Item No. **Report of the Head of Planning, Transportation and Regeneration**

Address THE BROADWAY 47 JOEL STREET EASTCOTE

Development: Erection of a three storey building to create a business unit and 1 x 2-bed residential unit involving demolition of existing store/garage to rear and remodelling of existing basement to increase business use

LBH Ref Nos: **17155/APP/2021/1453**

PL 02.01 C

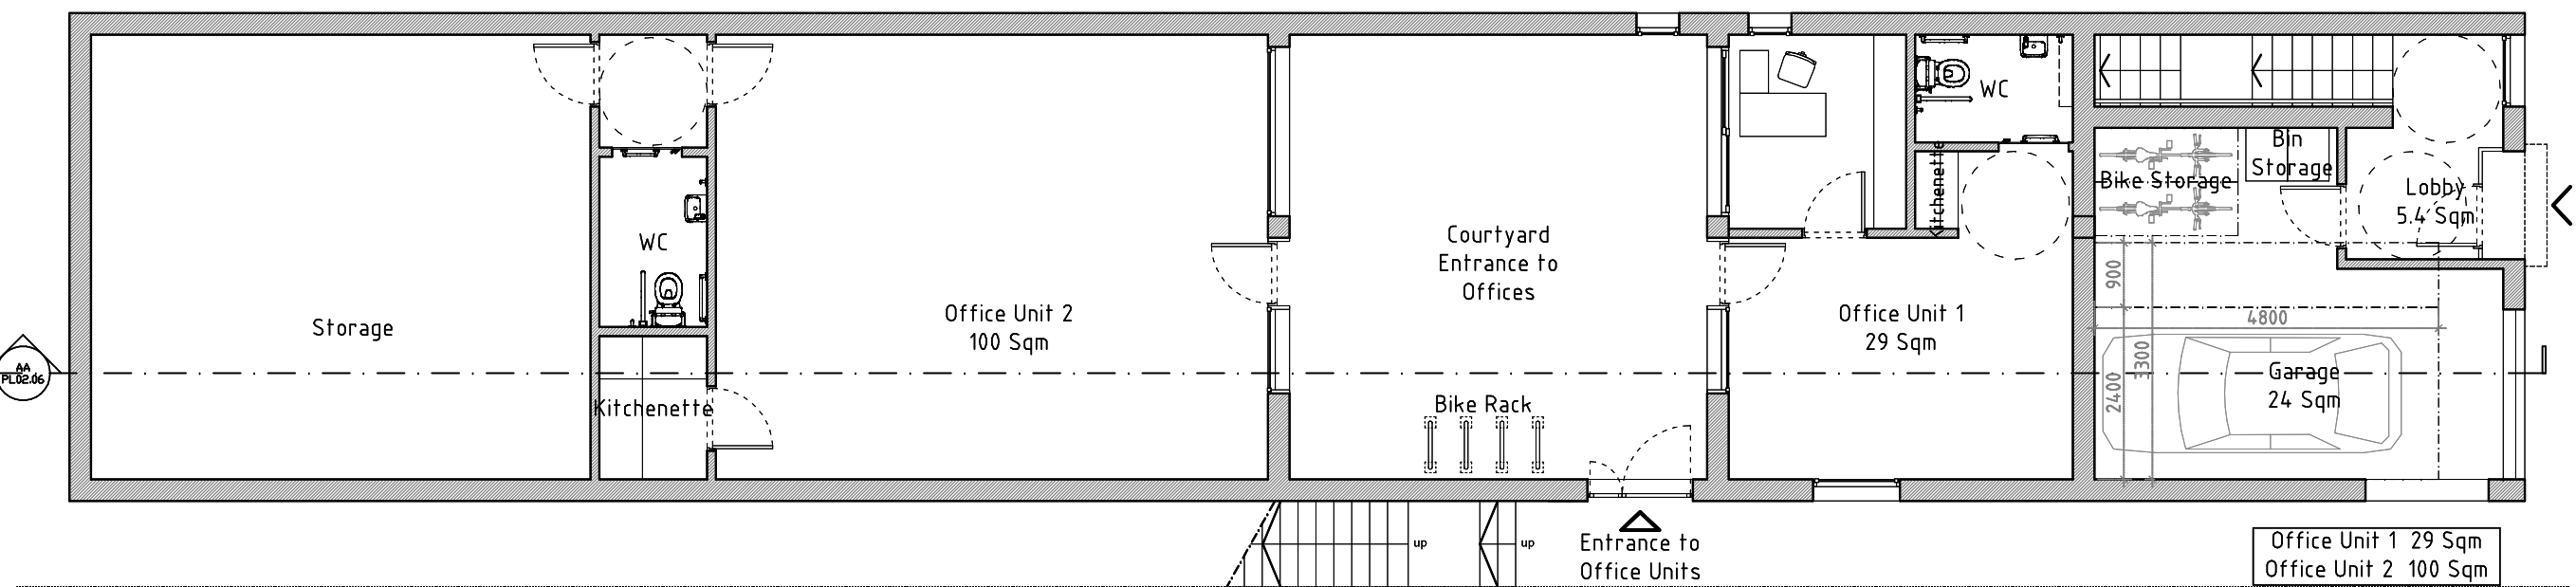
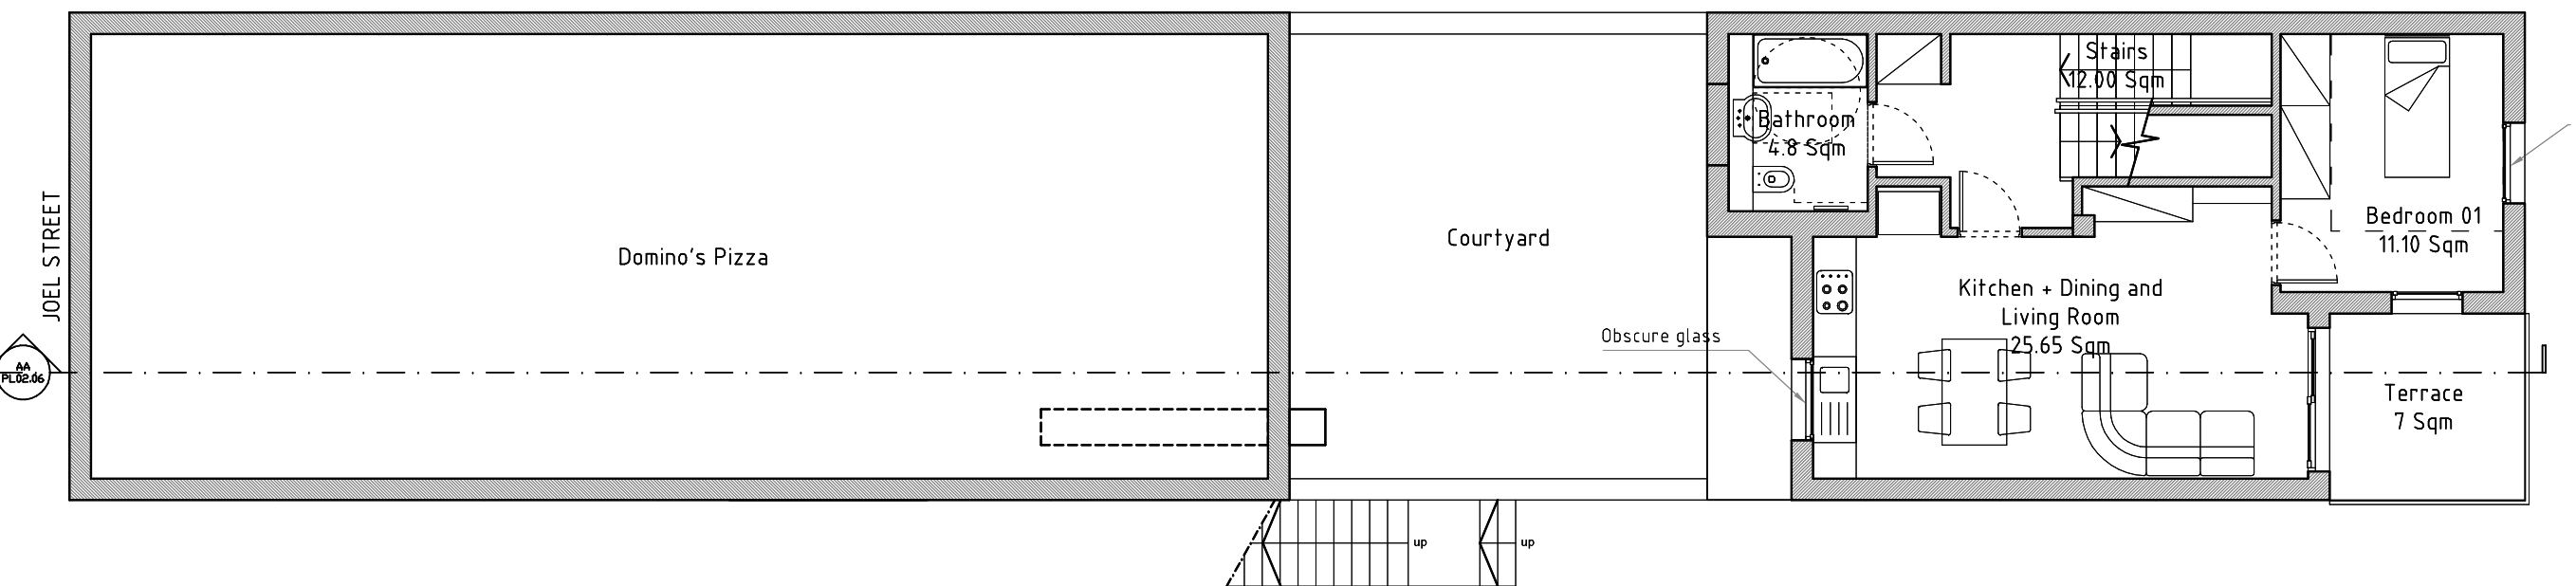
The proposal, by reason of its design and layout fails to provide a development which meets the requirements of people with disabilities and would therefore give rise to a substandard form of working and living accommodation to the detriment of the amenity of future occupiers. The proposal is thus contrary to Policies D5 and D7 of the London Plan (2021).

Conclusion: unacceptable. Justification for the lack of lift access to the residential units above lower ground floor should be submitted and evaluated prior to any approval.

DATE	DRAWING NO.	REVISION
05.10.2020		
SCALE		
1/100 @ A3	PL 02.06	C
ICE JOB NO.		
19.24.7		
CAD FILE NAME		
ICE19.24.7.PL.PRO.REV@	Copyright ICE ARCHITECTS LTD. 2021

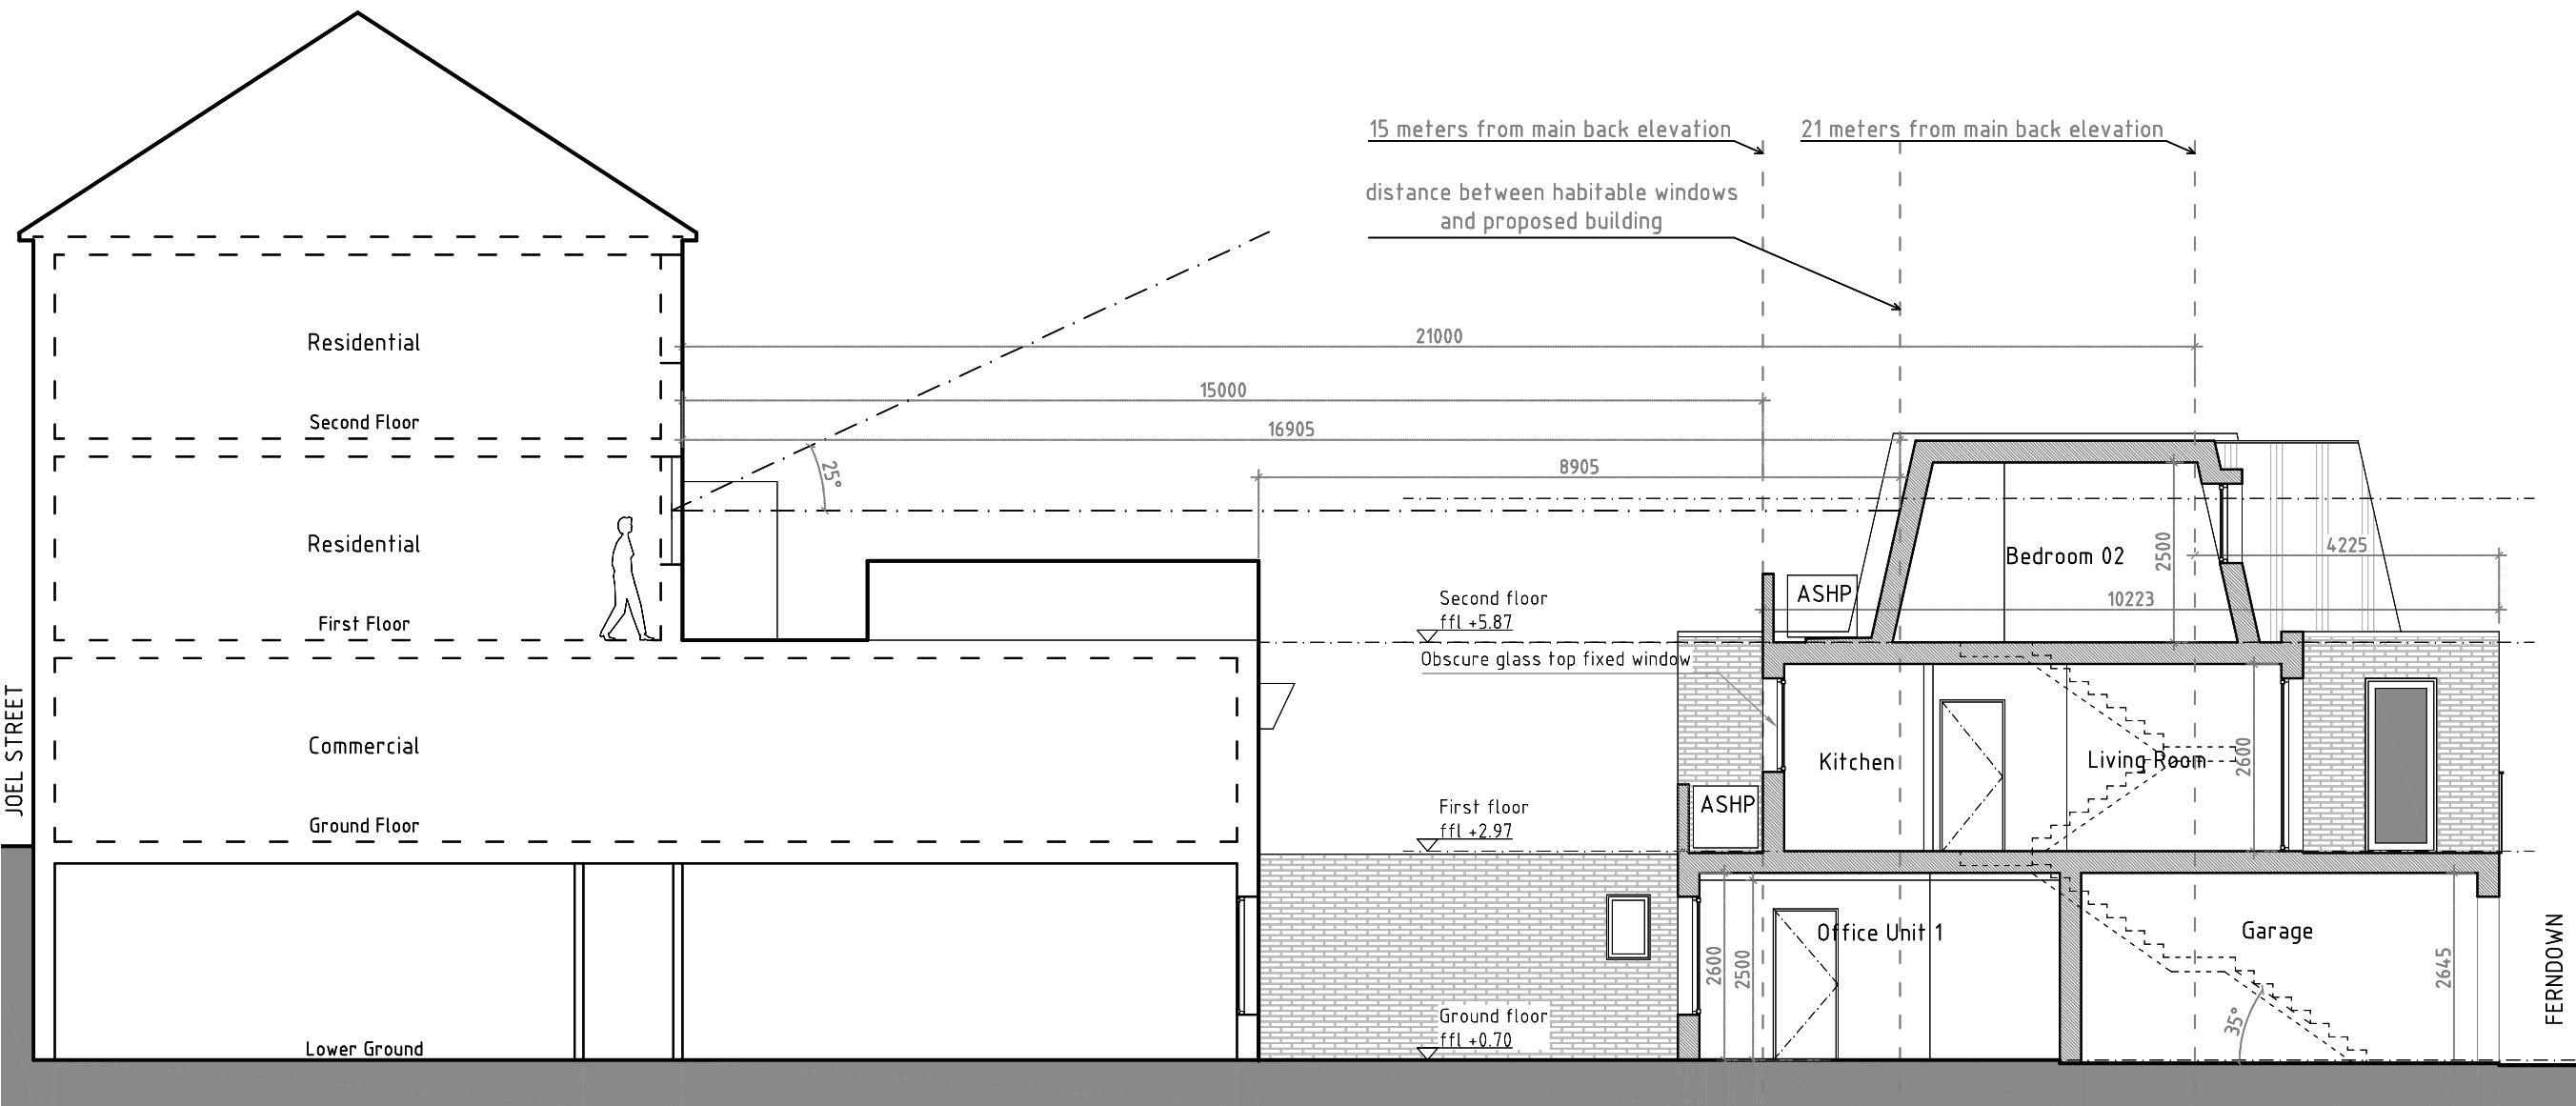
The bulk, massing and height of the development has been reduced. The previous application proposed a distance of approx 4.1 metres between habitable room windows at No. 47 and the development and this has been increased to approx 16.9m. It is considered that this distance would still be unacceptable and contrary to the Council's minimum requirement of 21m. Furthermore the development would still be only 8.9m from the terrace which forms part of the occupiers residential unit. As such it is considered that this development would cause harm to the amenity of residents at No. 47.

The development would also be only 10m away from the rear of No. 49 where there are two large habitable room windows and a terrace. As such it is considered that the development would cause harm to the amenity of residents of that property. This property abuts the existing 4 storey building at no 53-55 Joel Street, and as such already has a

restricted outlook. Given the scale and proximity of the development it is considered this would result in an overbearing impact on the amenity of the neighbouring occupiers.

The proposal includes a high level window serving a kitchen on its rear elevation facing the Joel Street properties. This would be obscure glazed to prevent any overlooking. It is noted that this kitchen would be served by a second window.

The proposed building would comprise a 3 storey mixed use block at a height of approximately 8.6m and a maximum width of 6.8m. Whilst the height of the building has been reduced since the submission of the refused application, its width is the same. The development would be set immediately adjacent to the road. This is a substantial building in a very prominent position, which would be an incongruous addition which would be unduly overly dominant and out of scale with the character and appearance of the area.
